20. COPE VIEW
EAST PRESTON
WEST SUSSEX
BN16 1AY

RE EP/48/18/POH.

REASONS FOR OPPOSING THIS PROJECT

Existing

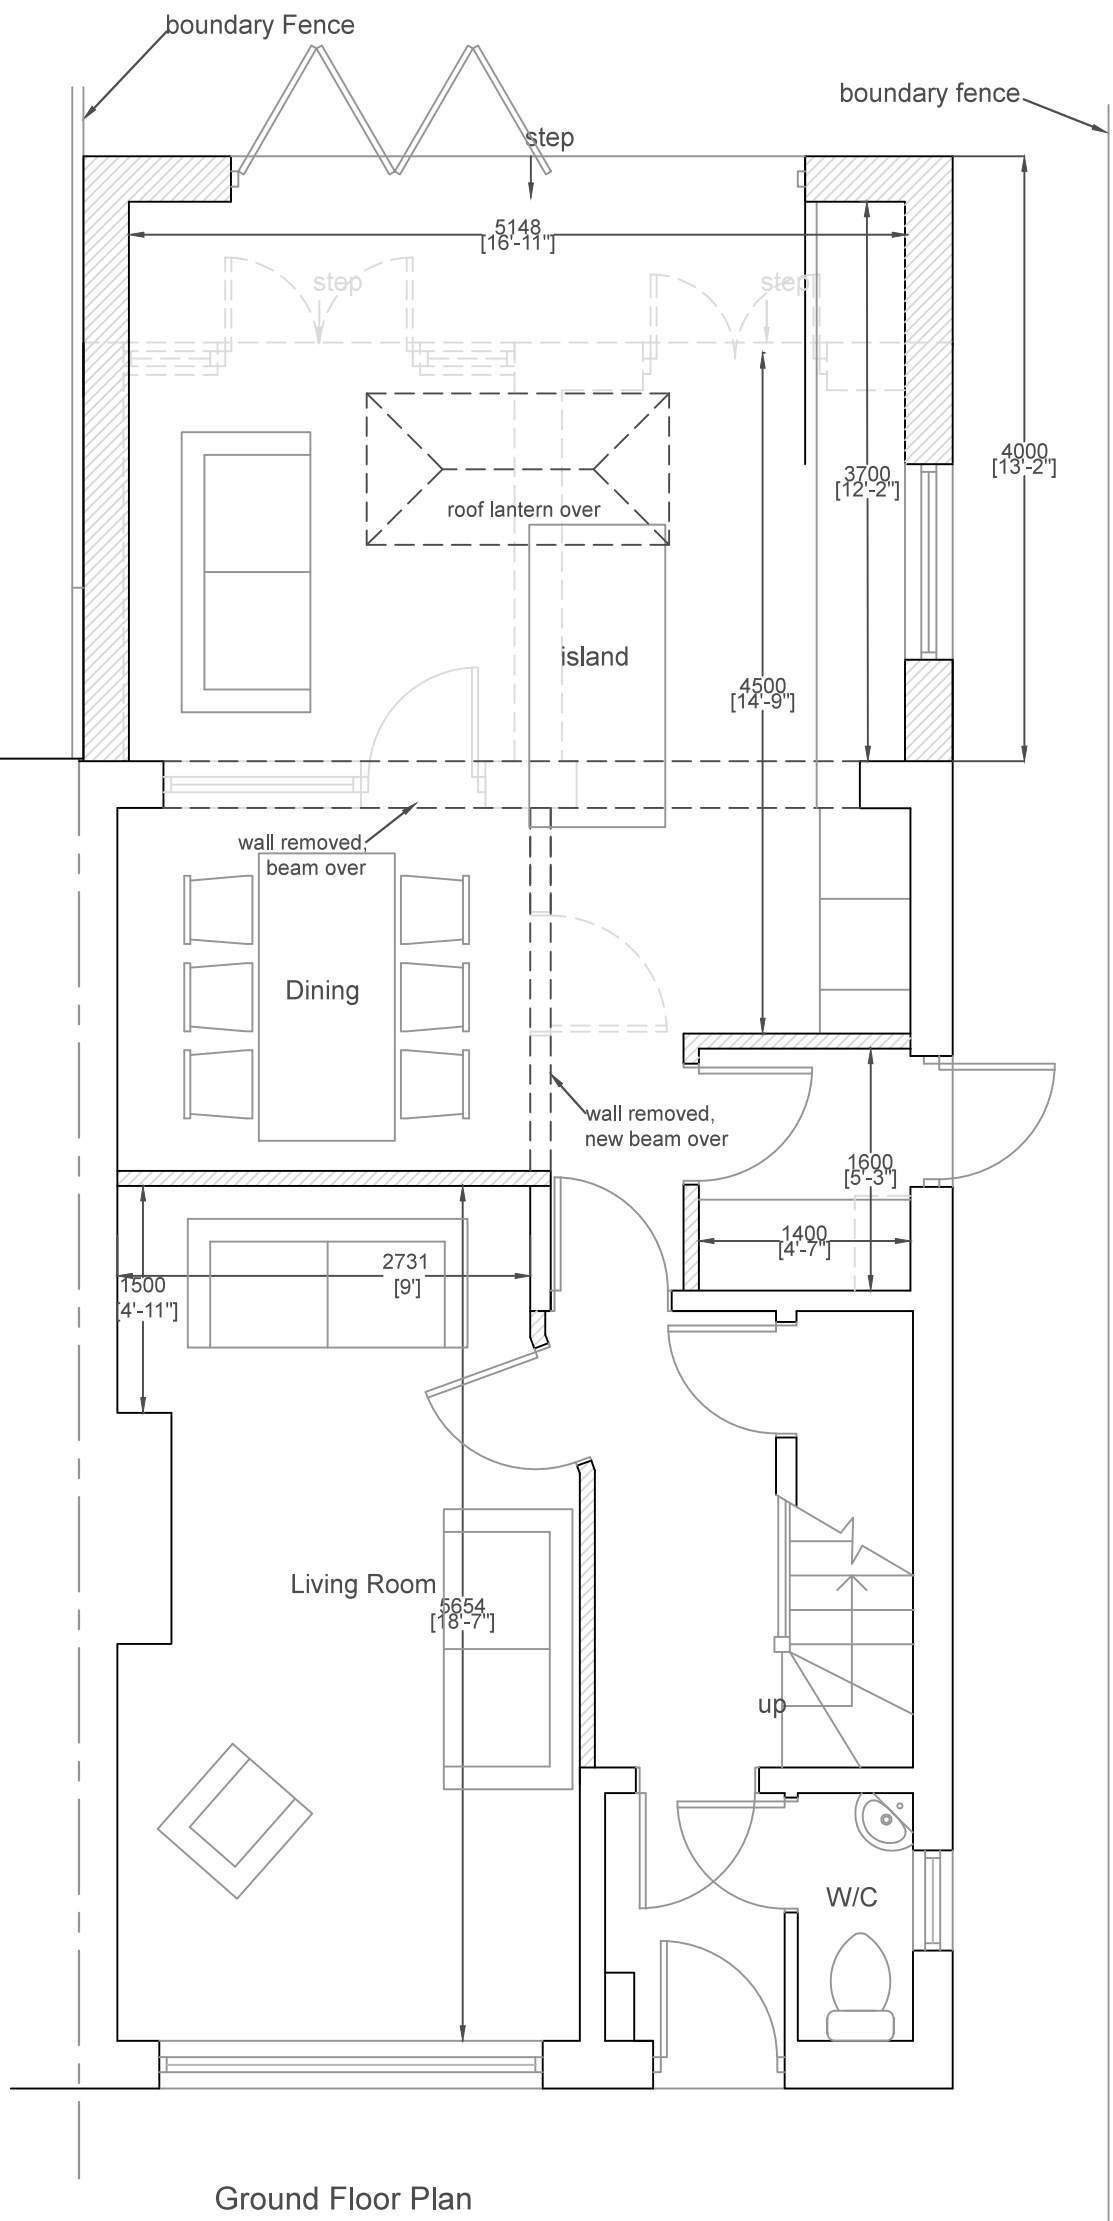
If this application is granted, it Looks from the Plans that he wants to Build about another 14" higher possibly to put windows above the fence Height so he can open the window. Well as the Situation is it could effect the sale and price of our House. the new build if granted needs to have a new wall built further into his garden so he can maintain the Wall and any window he might have from his own Land. I wonder what would happen if I were to take the fence down on the party wall line and built up a solid wall pass his windows I would like to get this problem resolved. because if I did want to sell, and managed to sell we would only be passing the problem on, and that cant be right.

- 1 BECAUSE THE WALL NEEDS TO BE MOVED OVER INTO HIS GARDEN SO IT CAN BE MAINTAINED PROPERLY FROM HIS OWN LAND AND NOT PUT OTHER PEOPLE OUT EXAMPLE CLEANING WINDOW AS ON THIS EXISTING BUILD.
- 2 AS THIS ABOVE SITUATION EXIST IT COULD DEVALUE OUR PROPERTY AND MAKE IT HARDER TO SELL.
- 3 THE EXTENSION WILL BE THE LARGEST BUILD ALONG OUR STRIP OF BACK GARDENS THE GARDENS ARE ONLY 51ft LONG AND 21ft WIDE SO OUT OF PROPORTION.
- 4 I WOULD BE THE ONLY HOUSE EFFECTED BY THIS PROPOSED BUILDING IT WOULD PROJECT 4m FROM THE ORIGINAL REAR WALL AND TOWER ANOTHER 14" HIGHER.
- 5 THE SIZES OF THE NEW BUILD WOULD CUT OUT A LOT MORE LIGHT FROM OUR DINING ROOM TUCKED UP BEHIND THIS EXTENSION. NOT TO MENTION THE AIRSPACE.

6 By the time this proposed extension is erected 4m from the rear original wall and the folding doors are left open. Plus the garden furniture & parasols plus the garden shrubs the other side of my fence in his garden there won't be much airspace in the I have kept a low fence for these reasons

THE PROJECT WILL HAVE A FLAT ROOF

WILL IT BEABLE TO SUPPORT A LADDER.
